Medworth Energy from Waste Combined Heat and Power Facility

PINS ref. EN010110
Document Reference Vol. 13.2
Revision: 1.0
Deadline: N/A
June 2023

Change Application Report

**Figure 10.1iv**  
**Cromwell Road/New Bridge Lane Signal Scheme - General arrangement**

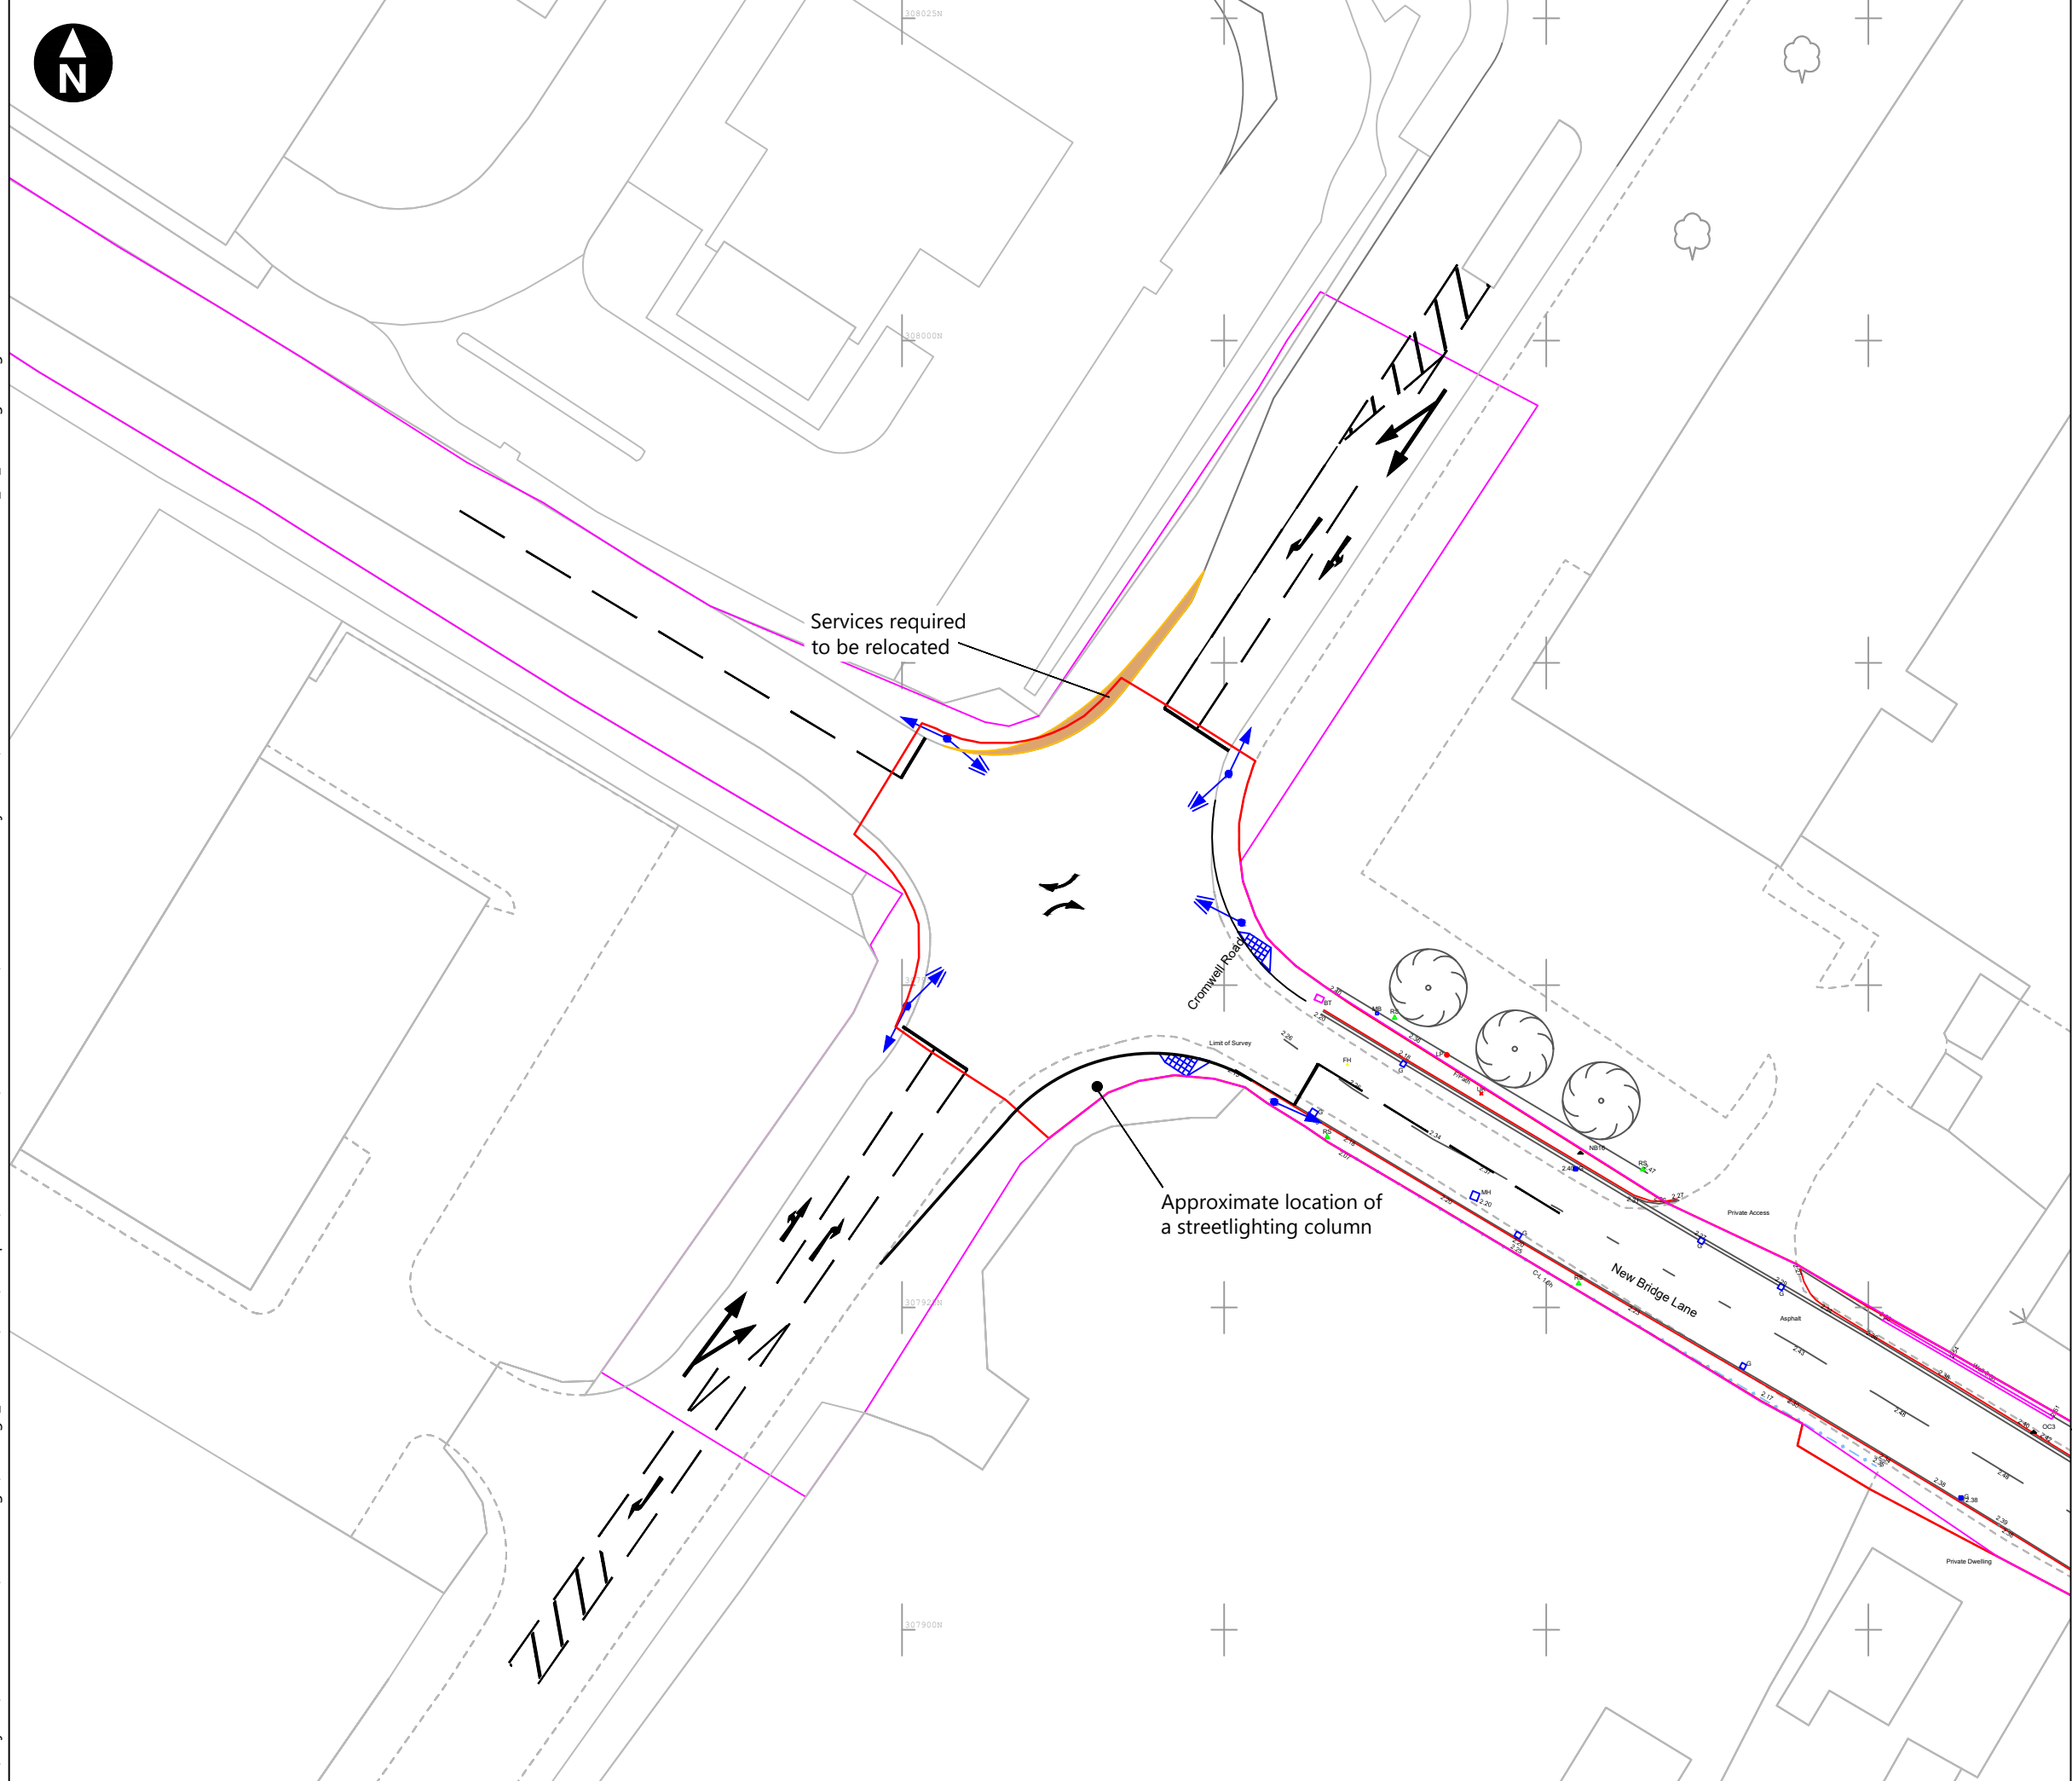
2.1.3 Figure 10.1iv of the Outline Construction Traffic Management Plan [REP1-010] and Figure 3.19iv of ES Chapter 3 Description of the Proposed Development - Figures 3.19 i-iv (Rev2) [REP1-009] submitted at Deadline 1 set out the general arrangement of the proposed signal scheme at the Cromwell Road and New Bridge Lane Junction. This figure identified the proposed location of the primary and secondary signal heads (traffic lights), kerb realignment and the indicative road marking scheme.

2.1.4 Following discussions with highway officers at CCC, the Applicant and CCC have agreed in principle, subject to a junction assessment and stage one safety audit, a revised signal scheme (as shown on the plan attached to this letter).

2.1.5 In order to facilitate the revised signal scheme, the Applicant proposes to extend the Order limits to include additional areas of the existing and future public highway as shown indicatively coloured orange on the plan attached to this letter. In respect of the existing public highway, as the Applicant will only be undertaking highway works pursuant to Article 11 of the draft DCO [REP3-007] in these additional areas, no compulsory acquisition powers are required over these additional areas. In respect of the remaining land, whilst this land constitutes a street (as defined in the draft DCO), this land is subject to a section 106 Agreement between CCC and Tesco Stores Limited that provides for its future dedication as public highway (i.e., it is not currently maintainable at public expense). All works to this land by the Applicant will be undertaken using either the powers to carry out works to a street in Article 11 of the draft DCO [REP3-007] and/or temporary possession powers pursuant to Article 32 of the draft DCO [REP3-007]. No compulsory acquisition powers are required over this small additional area outside the current public highway extent.

2.3.1 The proposed layout of the Cromwell Road Junction Signal Scheme signal scheme is shown as Figure 3.19iii REV1A Cromwell Road/New Bridge Lane Signal Scheme – General Arrangement in Appendix C. The proposed scheme is comprised of the following components:

- Provision of stop lines and primary and secondary traffic signal columns on all arms of the junction;

- Realignment of the kerbs throughout the junction to accommodate additional lanes and the swept path of anticipated HGV movements.
- Provision of islands within the junction to accommodate the new traffic signal equipment.
- Provision of signalised right turns on the B198 Cromwell Road North and South arms with right turn only lanes and right turn road markings mid junction.
- Provision of a signalised pedestrian crossing over New Bridge Lane East arm.
- Provision of all necessary road markings to ensure clear guidance to vehicles.

**Figure 3.19i**  
**New Bridge Lane access proposal**

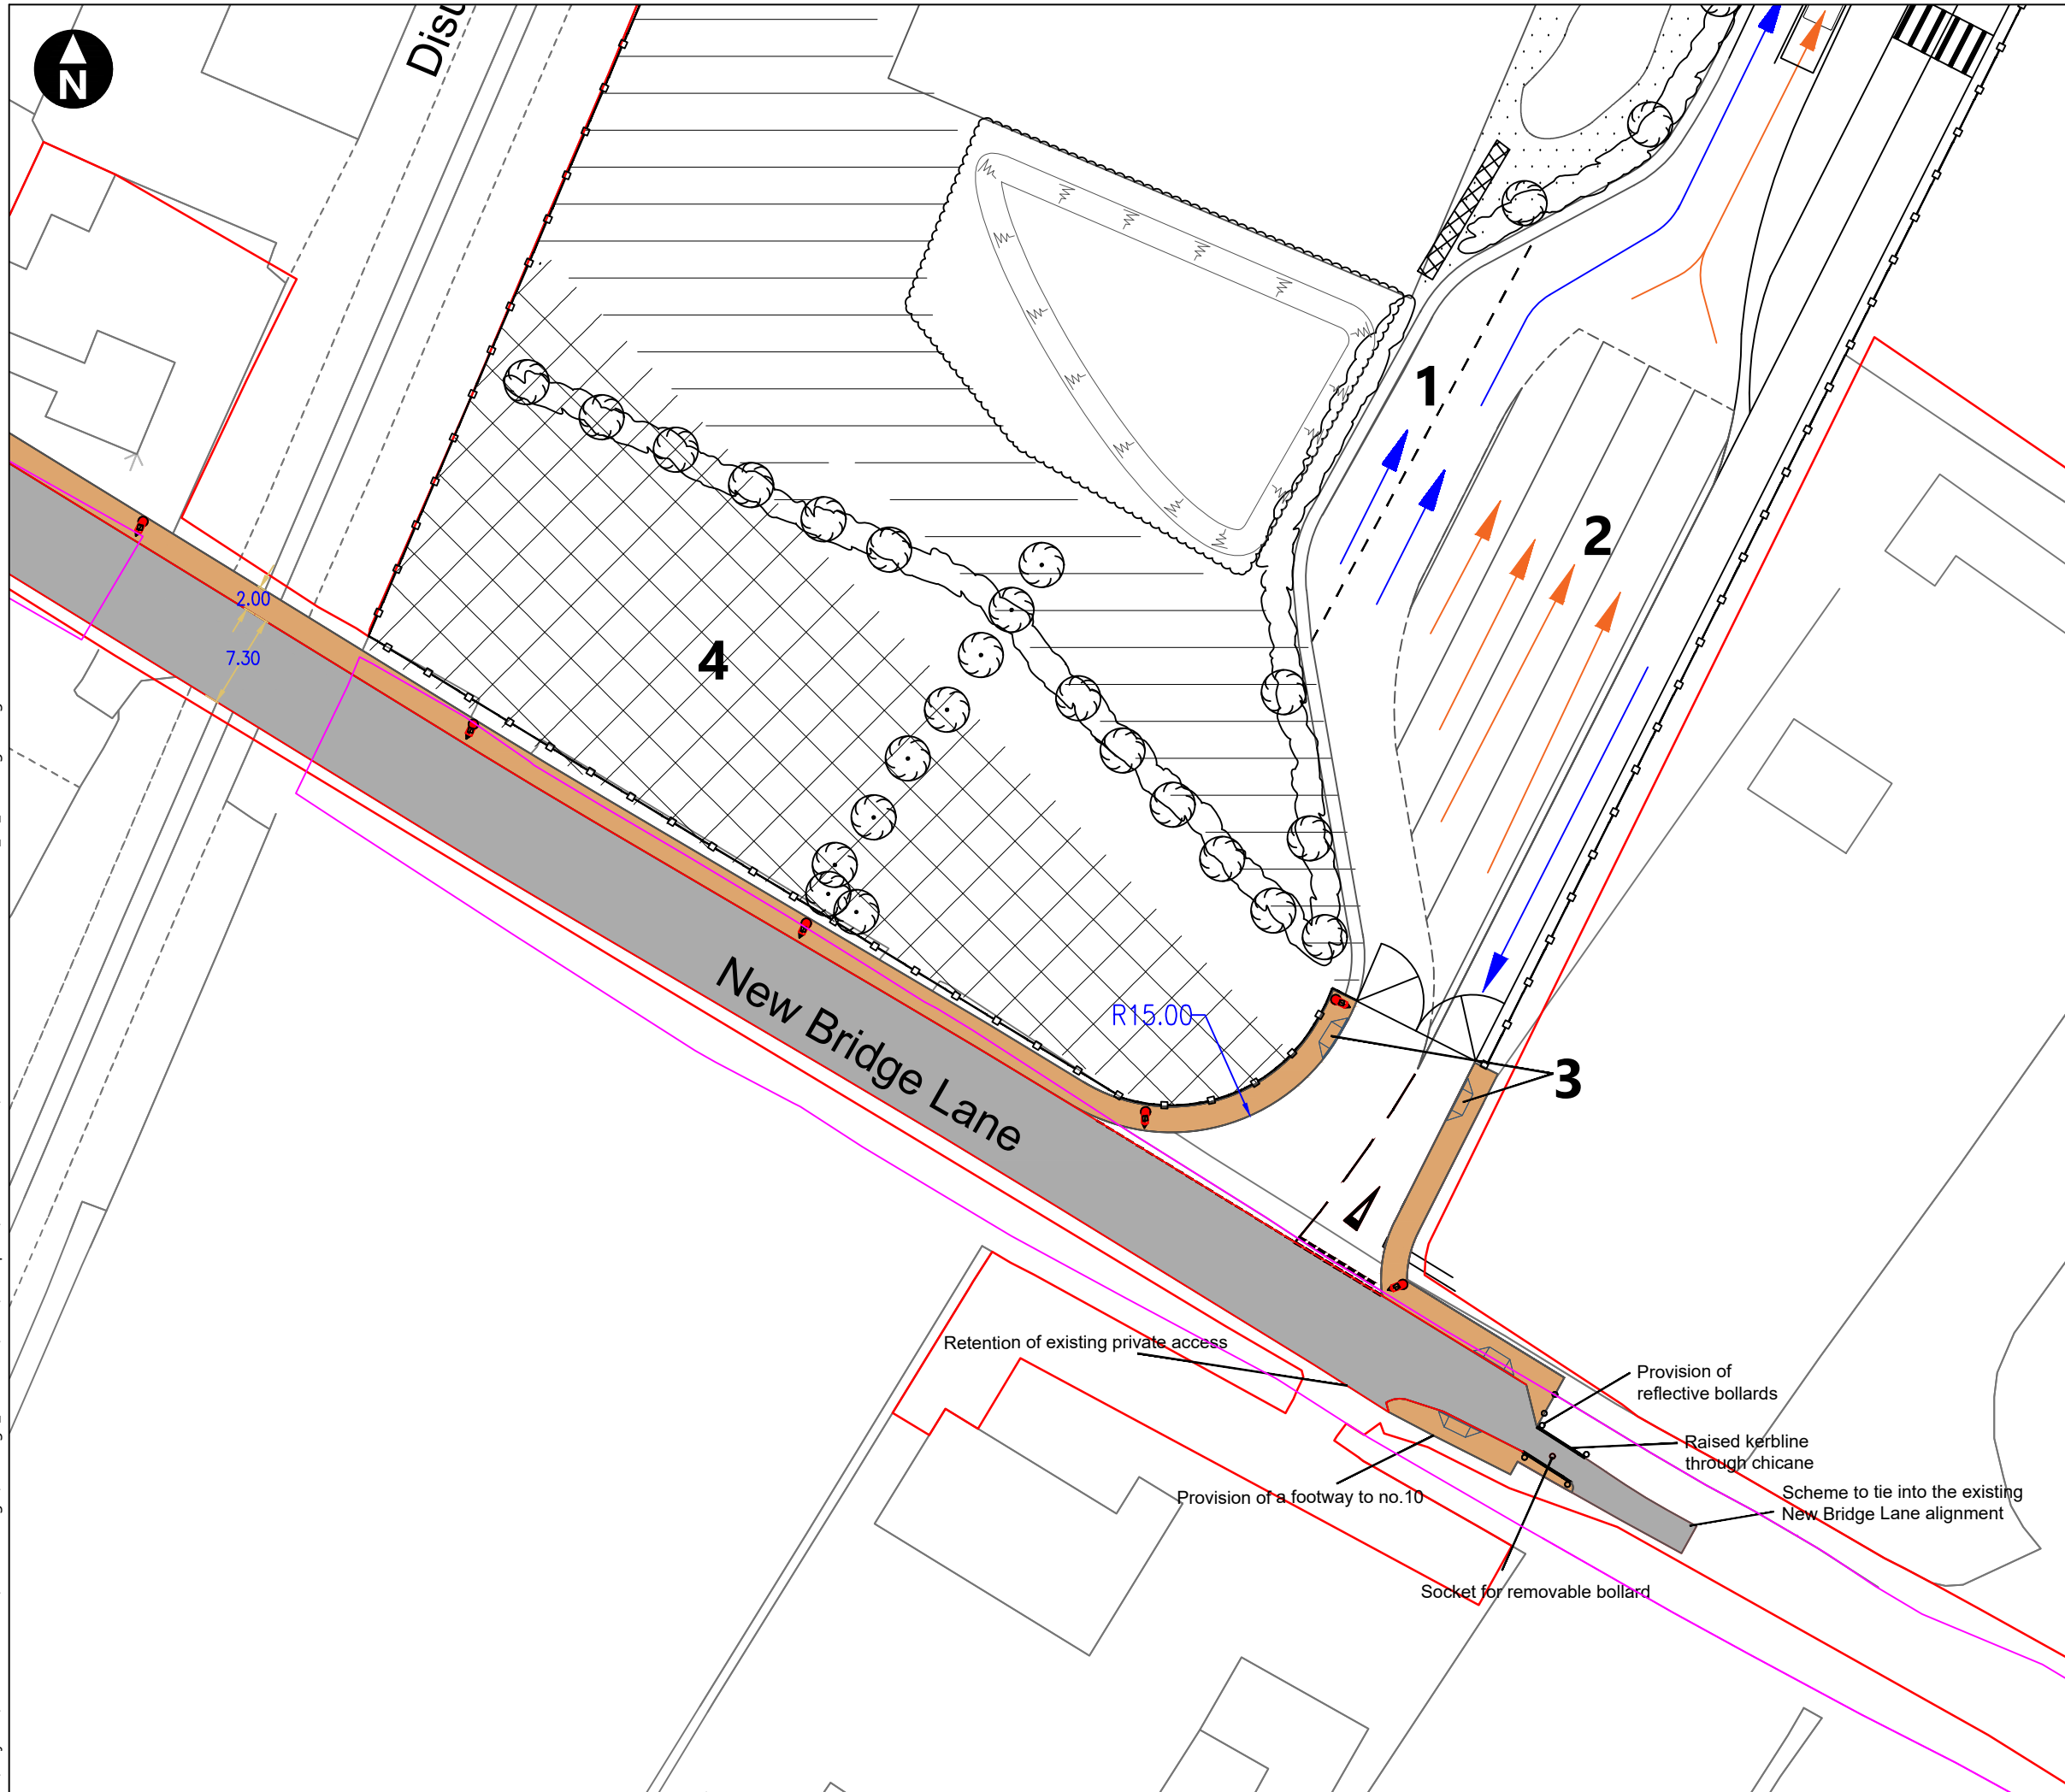
- 2.1.8 Figure 3.19ii of ES Chapter 3 Description of the Proposed Development - Figures 3.19 i-iv (Rev2) [REP1-009] submitted at Deadline 1 identified the provision of two new dropped kerbs at the junction of New Bridge Lane and Salters Way. The Applicant notes that the proposed dropped kerbs were included to enable pedestrians to safely cross Salters Way.

- 2.1.9 During the technical discussions with the highway officers at CCC it was identified that the proposed dropped kerbs were located outside of the existing Order limits.

- 2.1.10 In order to facilitate the construction of the proposed dropped kerbs to Salters Way Junction, the Applicant proposes to extend the Order limits to include additional areas of the existing public highway as shown indicatively coloured orange on the plan attached to this letter. As the Applicant will only be undertaking highway works to the existing public highway pursuant to Article 11 of the draft DCO [REP3-007] in these additional areas, no compulsory acquisition powers are required over these additional areas.

2.3.3 The Salters Way Junction Pavement Works consist of improvement works in the form of a dropped kerb crossing with tactile paving which is planned for the southern end of Salters Way for the benefit of pedestrians and other non-motorised users. These works will be located within the existing footpath and will provide a formal point of crossing for the benefit of all pedestrians but particularly those with pushchairs, wheelchairs or with restricted vision. The pavement works are shown as Figure 3.19i REV1A New Bridge Lane Access Proposals in Appendix C.
